Applicant: Oxford University Development Ltd

Proposal: Discharge of Conditions 18 (turning area specification) and 20
(Construction Traffic Management Plan) of 18/00803/OUT

DATE: 18 July 2022

TITLE: **Additional 7 parking Spaces**

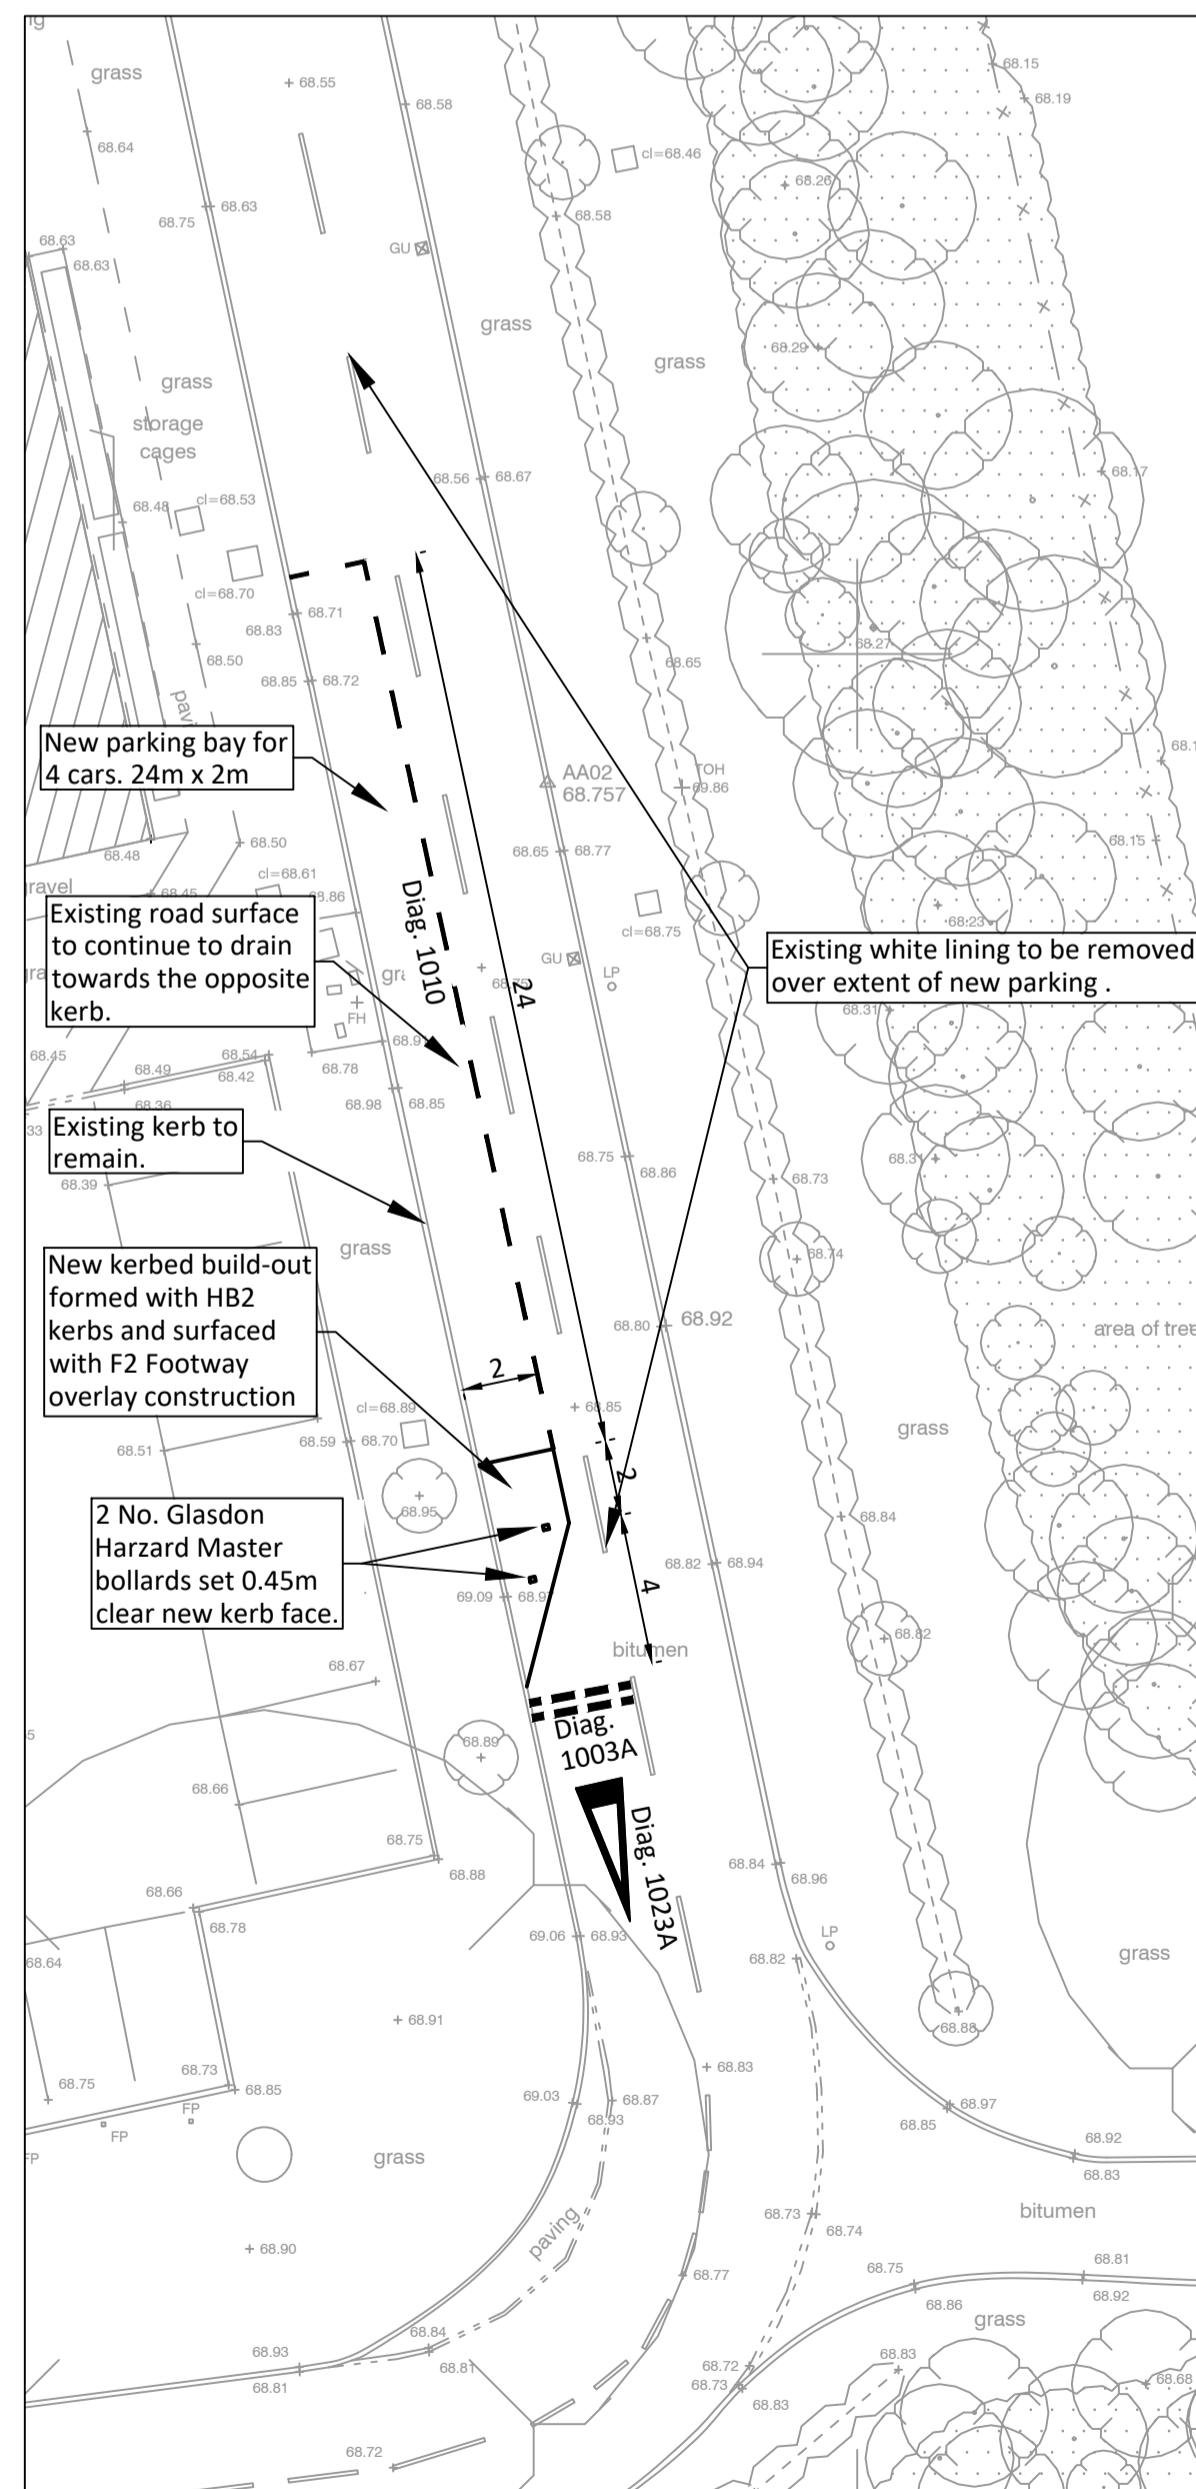
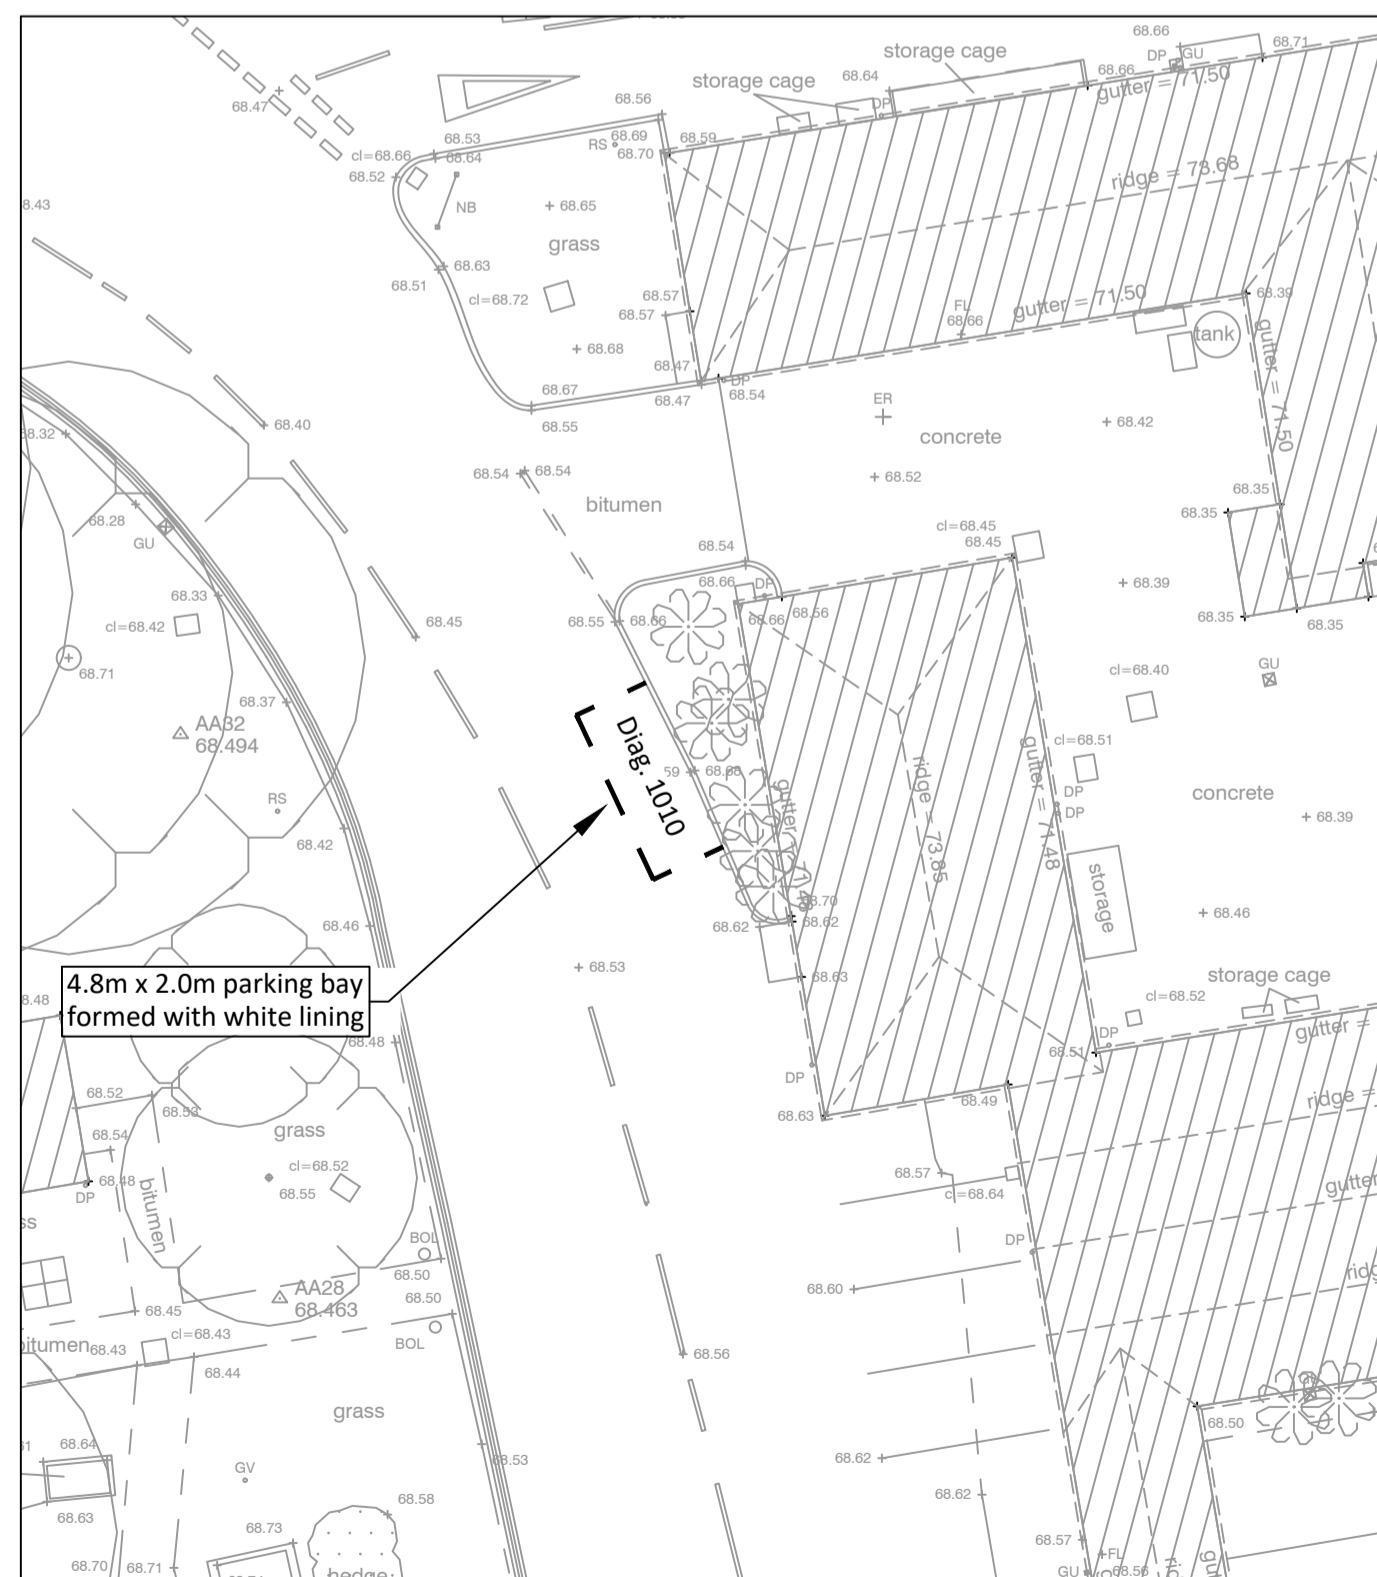
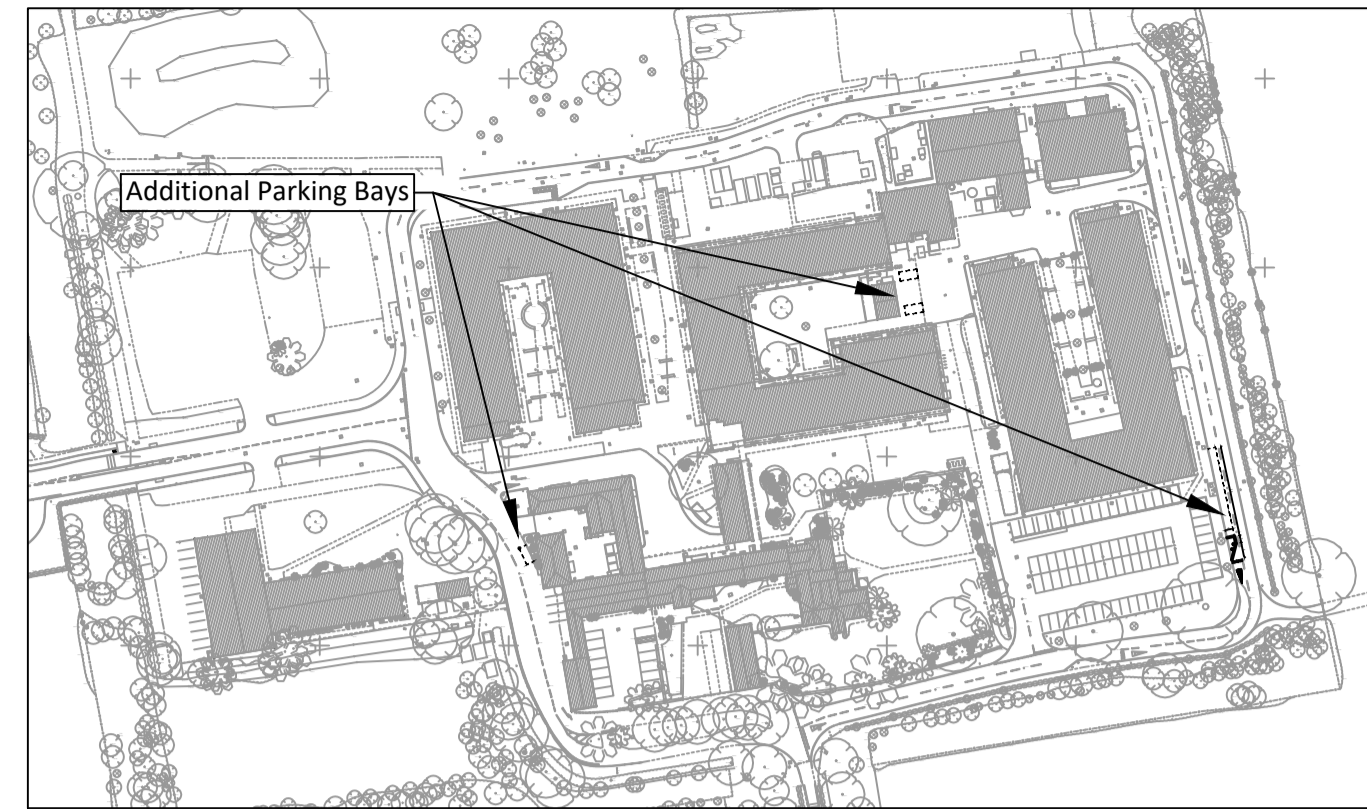
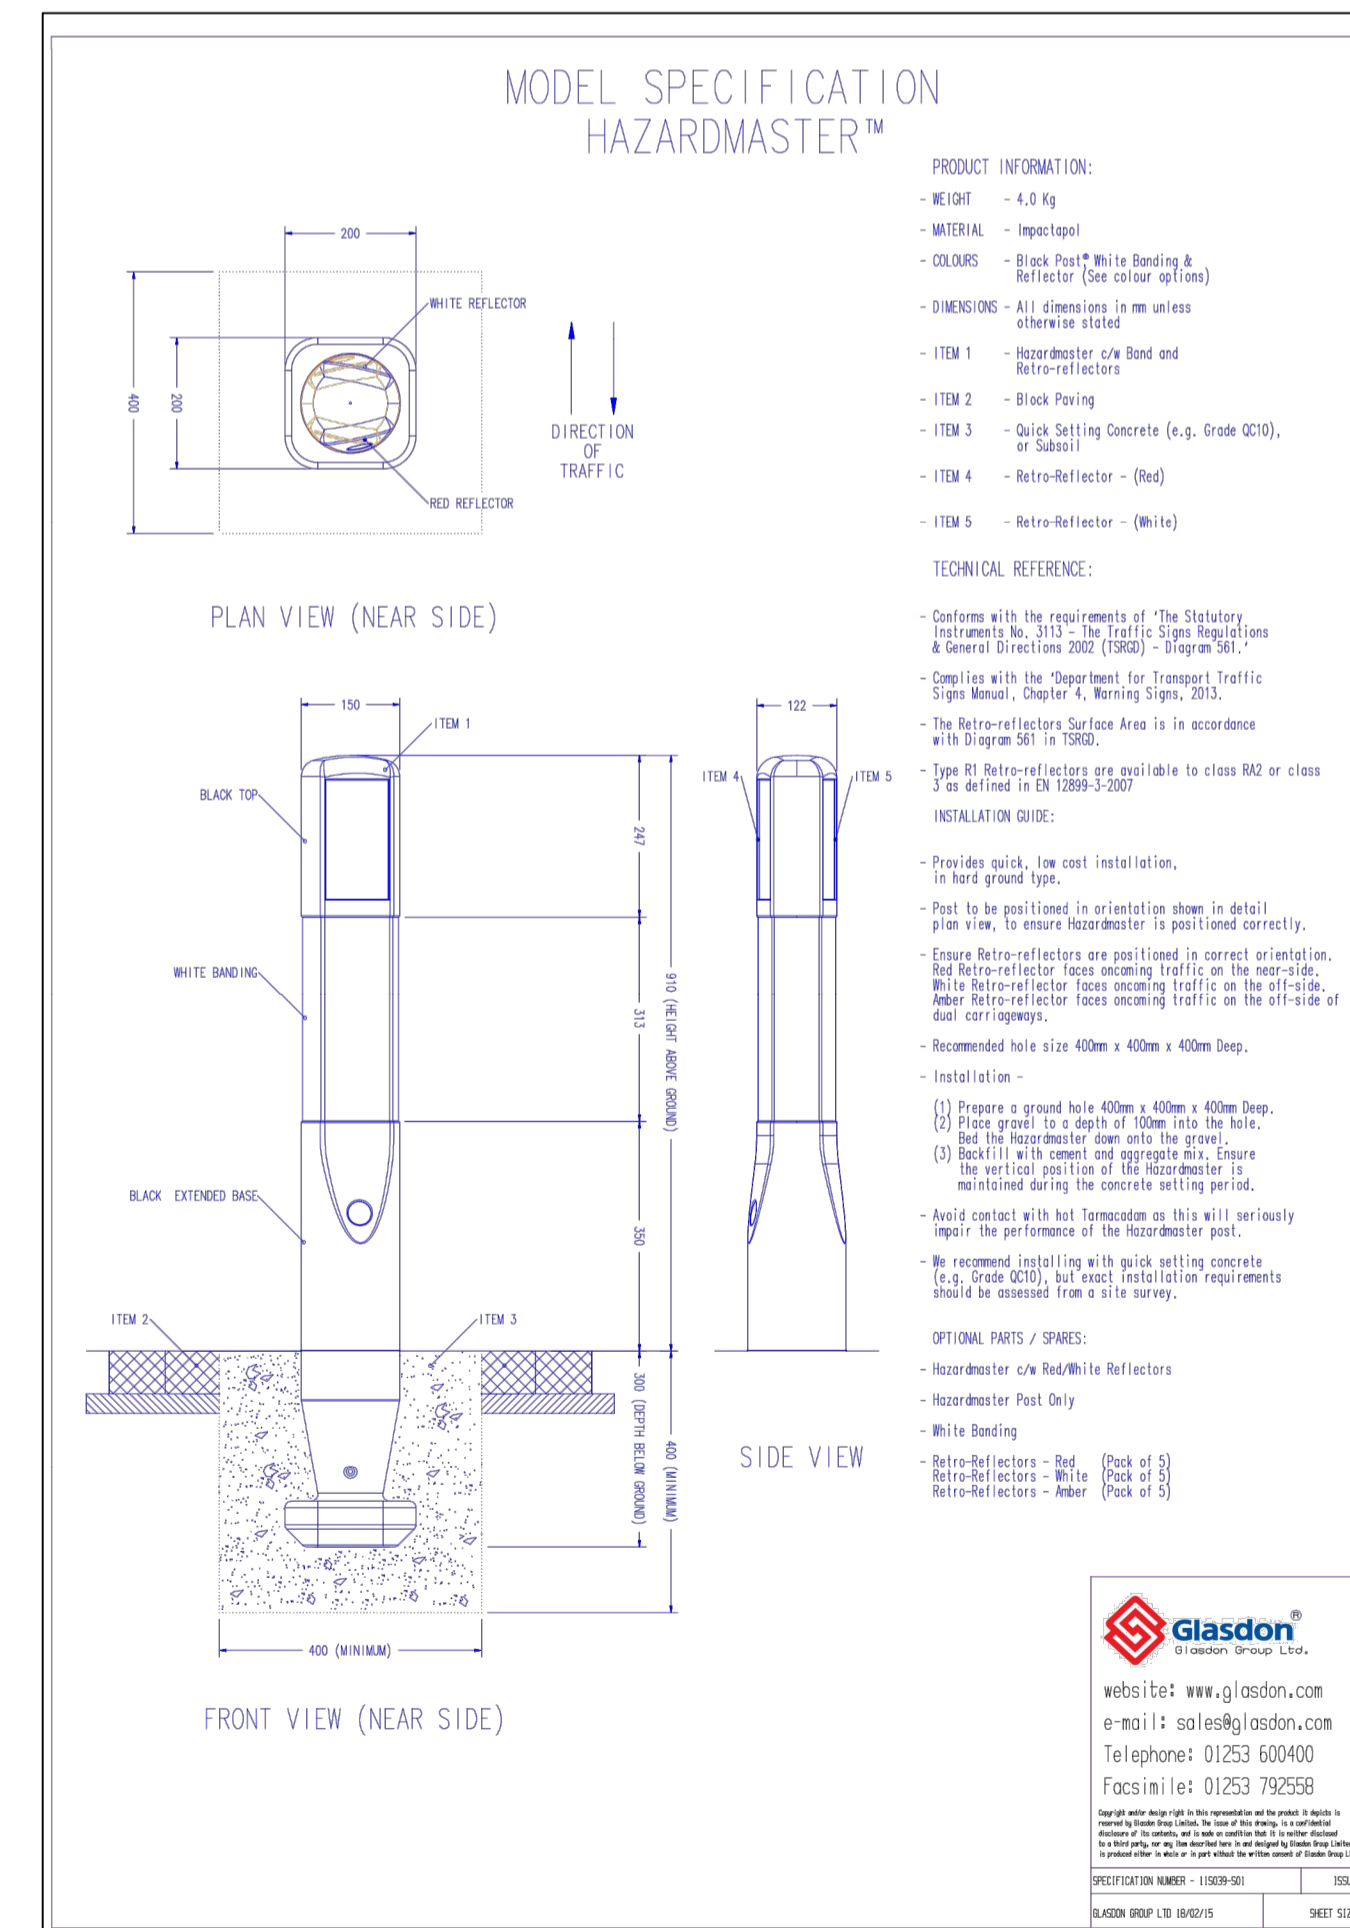
- 4.1 **OCC – Transport** – Initial objection to the discharge of conditions 18 and 20. Not all vehicle spaces within the site including those that are situated within the car park have the required 6.0m manoeuvrability and the number of spaces pictured within Appendix 1 does not match those detailed within the technical statement. The names of the project supervisor and site manager were disclosed, but no contact details provided and the secondary access via Sandy Lane states within the plan

6.1. Condition 18 – This condition relates to parking provision and manoeuvring within the site. The submitted drawings and documentation were assessed by OCC as highway authority who raised an initial objection. The OCC guidance for space between vehicle parking bays measures 6.0m so that cars can swing into spaces. Many of the spaces did not comply which ultimately jeopardises the condition as it may restrict vehicles' ability to reverse and leave the car park forwards as well as general manoeuvrability and convenience. This was emphasised by the exclusion of a turning area. This will need to be amended before the condition can be discharged. The number of spaces to be provided is unclear and must be clarified.

6.2. Following a meeting with OCC, the proposals were clarified and amended accordingly, and the revised proposals are now acceptable to OCC. It is therefore agreed that this condition can be discharged accordingly, based on the revised plans.

Drawing numbers: IMA-21-071-016 Rev D; LP2264-FIR-00-ZZ-DR-L-0007 Rev 02 and as clarified by comments to OCC by agent to initial consultation response dated 30.06.2022 and Technical Note dated February 2022.
